Date: 28-Jul-2025
Our Ref: 2025/90352

**Application for Approval of Details Reserved by Condition
Town and Country Planning Act 1990
Planning (Listed Buildings and Conservation Areas) Act 1990**

Discharge of details reserved by conditions 6 (boundary treatments), 8 (intrusive site investigations and remedial works), 9 (declaration), 10 (Phase I Desk study Report), 11 (Phase II Intrusive Site Investigation Report), 12 (Remediation Strategy), 13 (Remediation Strategy), 14 (Verification Report) and 15 (Arboricultural Method Statement and Tree Protection Plan) of previous permission 2024/93464 for variation condition 2 (plans) on previous permission 2023/91483 for demolition of garage and erection of detached dwelling.

**adj, 33a, Church Lane, Clayton West, Huddersfield, HD8 9LY
Application Number: 2025/90352**

Boundary Treatment Plan

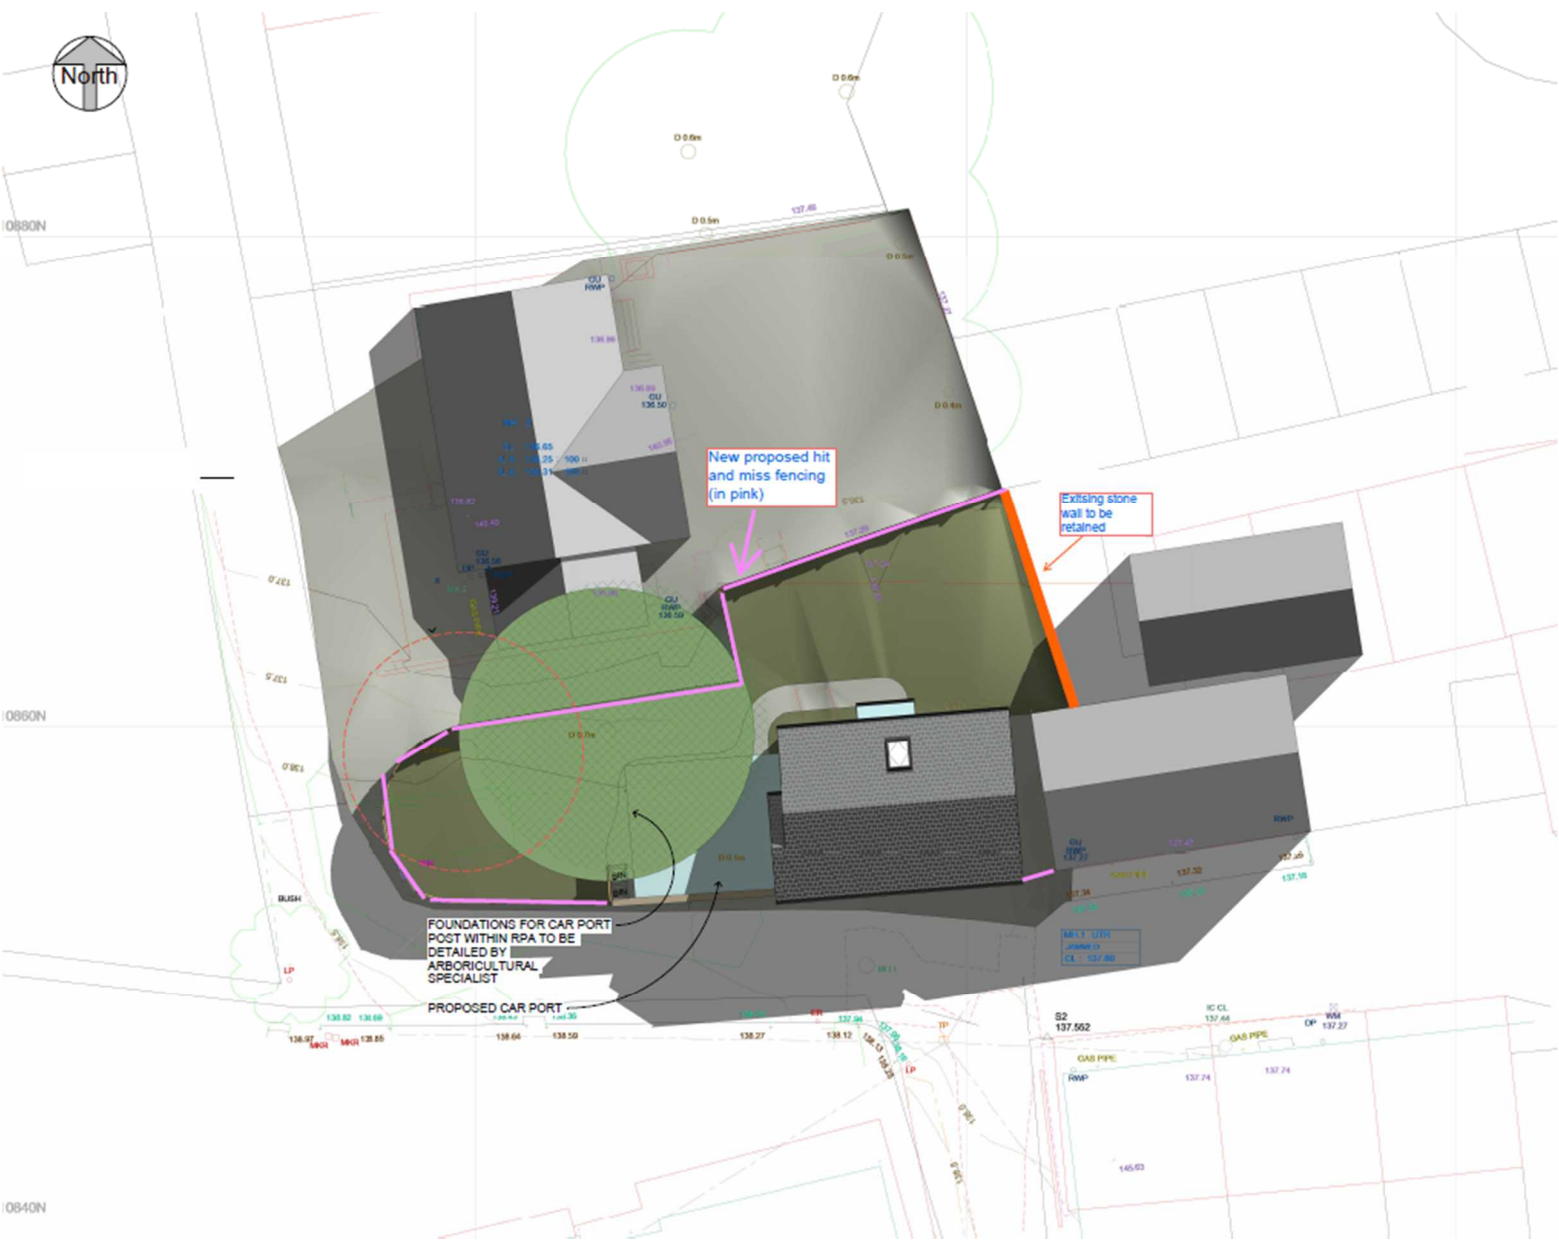
The first page shows the location of a ‘new proposed hit and miss fencing’ to the northern, western and southern boundaries of the site. The fencing would be 1.8 to the north and west and 1.6m to the south. The existing stone wall would remain intact along the eastern boundary and part of the southern boundary.

Officers have concerns regarding the height of the proposed fence adjacent to the access with both the parking for the approved dwelling and the existing access to 33a Church Lane. Officers asked the applicant to demonstrate visibility splays on the plans to demonstrate that this would not interfere with visibility however this has not been provided.

Similar details were submitted and refused under application 2024/93179. The officers report for this application stated, “a 1.8m fence adjacent to a vehicular access would not be acceptable as it would raise concerns relating to visibility.”

Condition 6 can therefore not be discharged at this time.

Swept Path Analysis – Holmfield, Clayton West

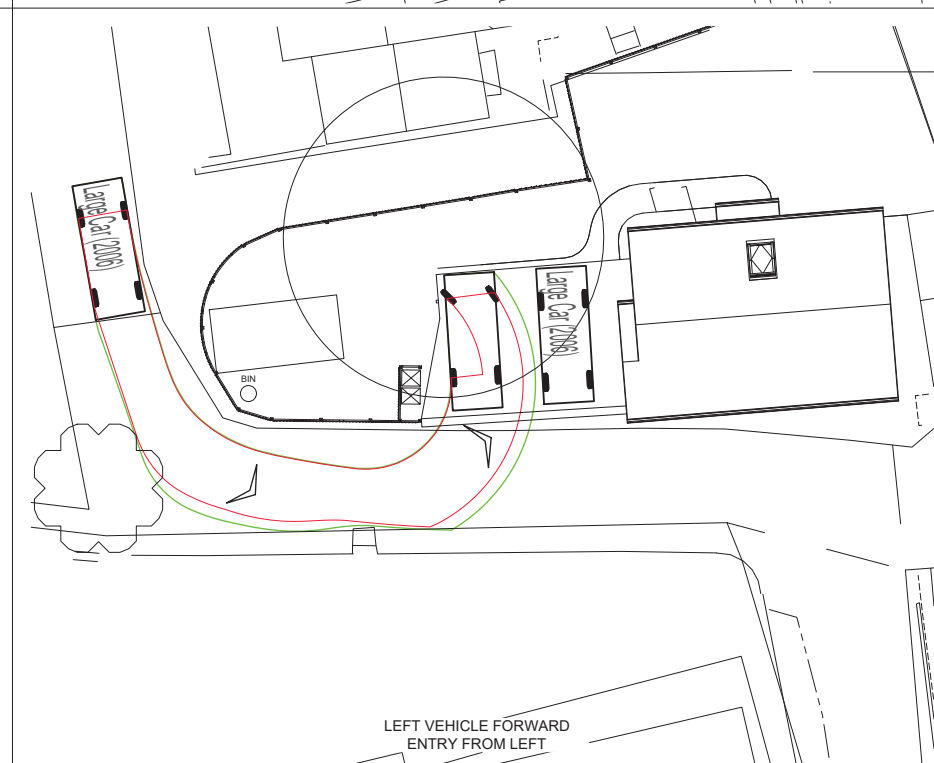
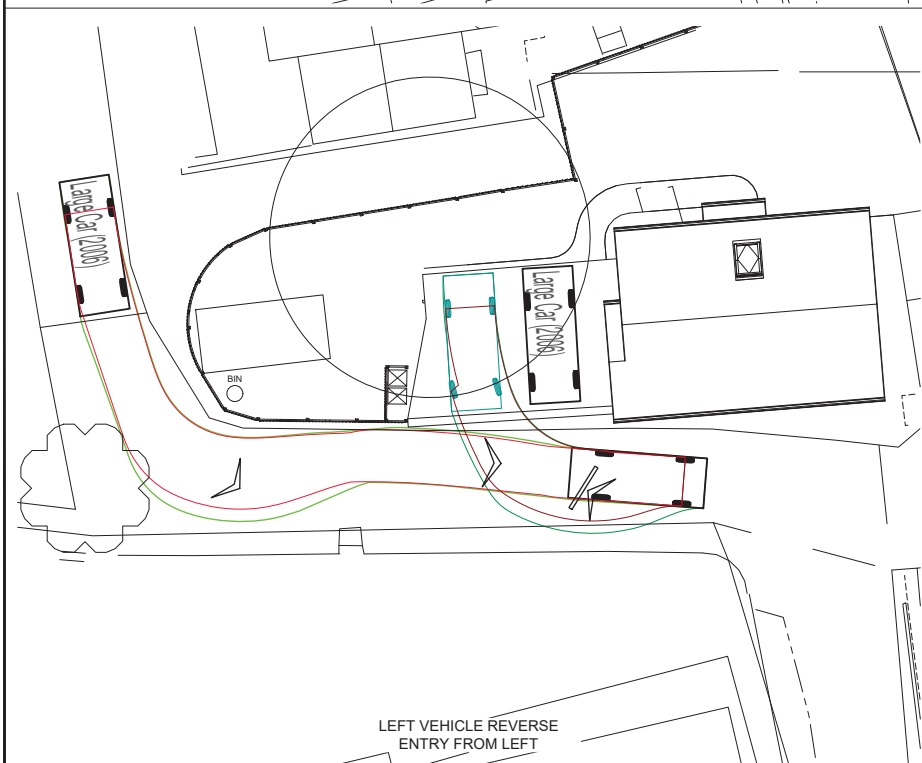
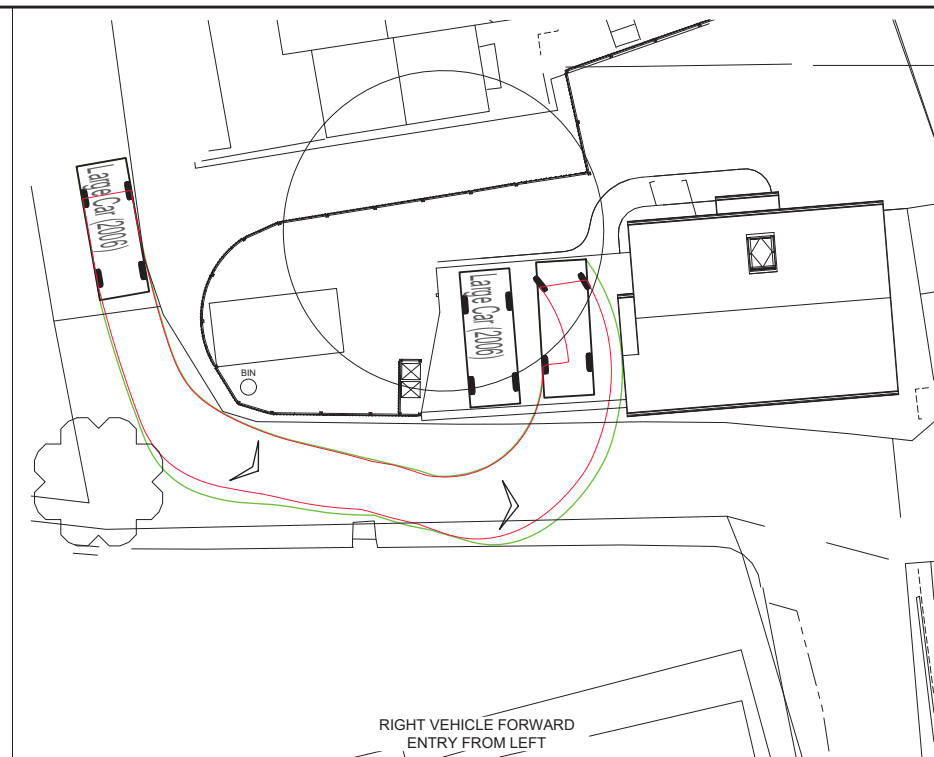
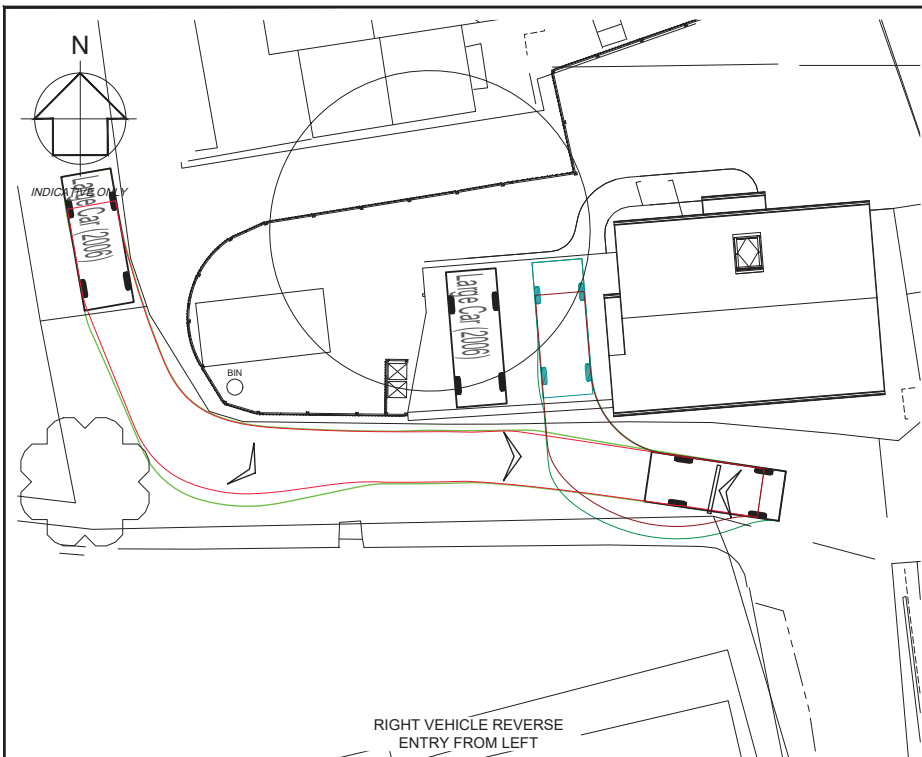
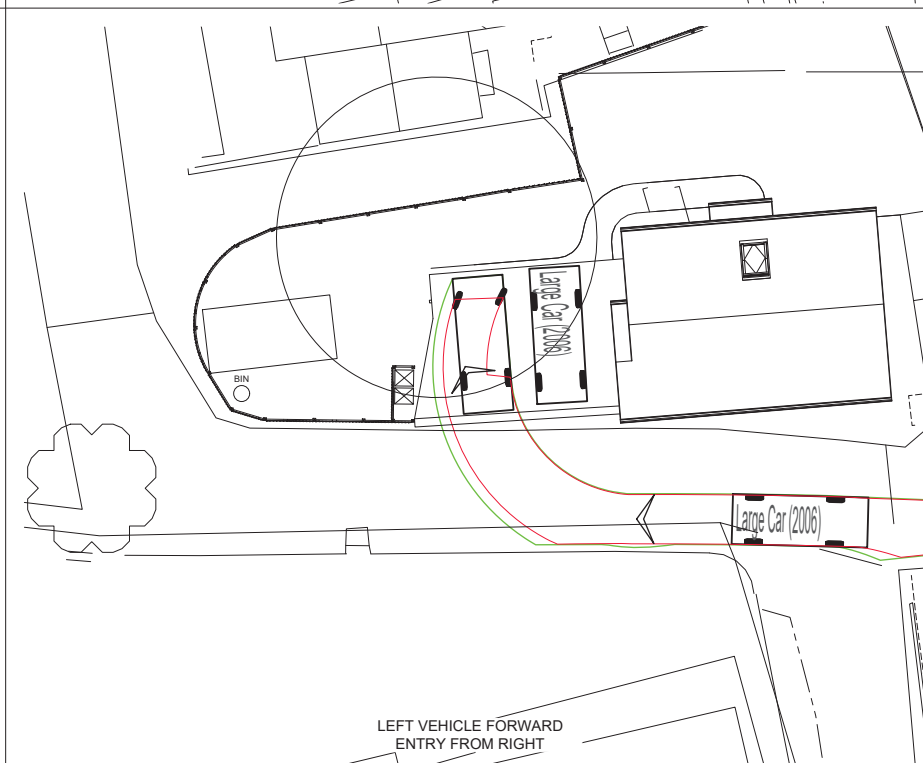
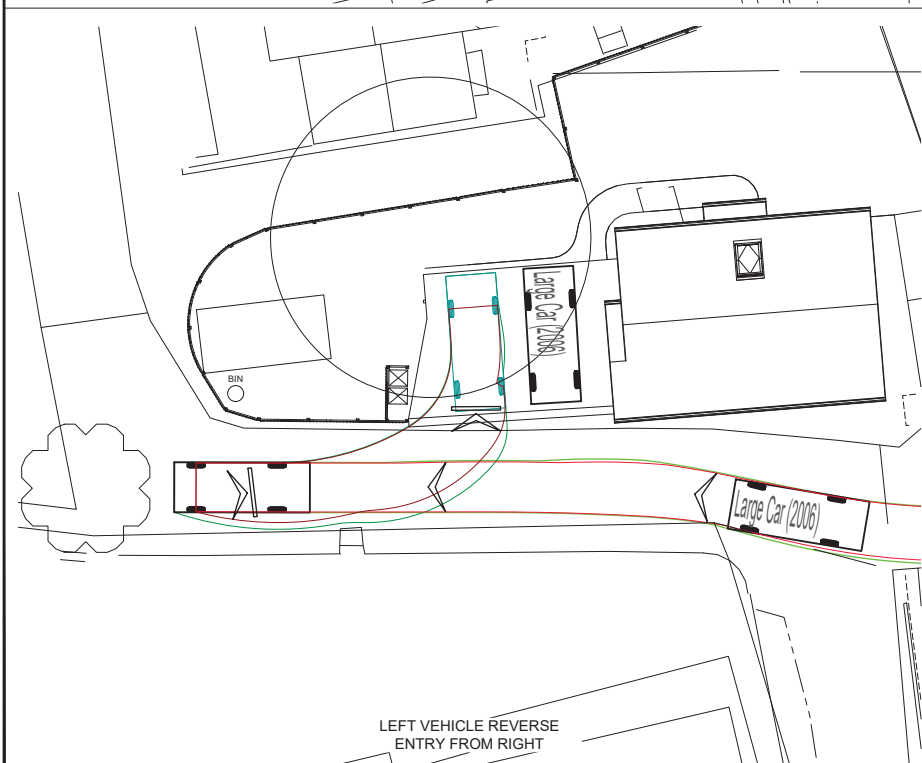
The submitted information shows turning splays for a 5.079m vehicle entering and existing both parking spaces from the east and west. KC Highways have been informally consulted on the submitted plans and have no objections to the proposed turning splays.

The details are therefore sufficient for the discharge of condition 16. Condition 16 can therefore be discharged.
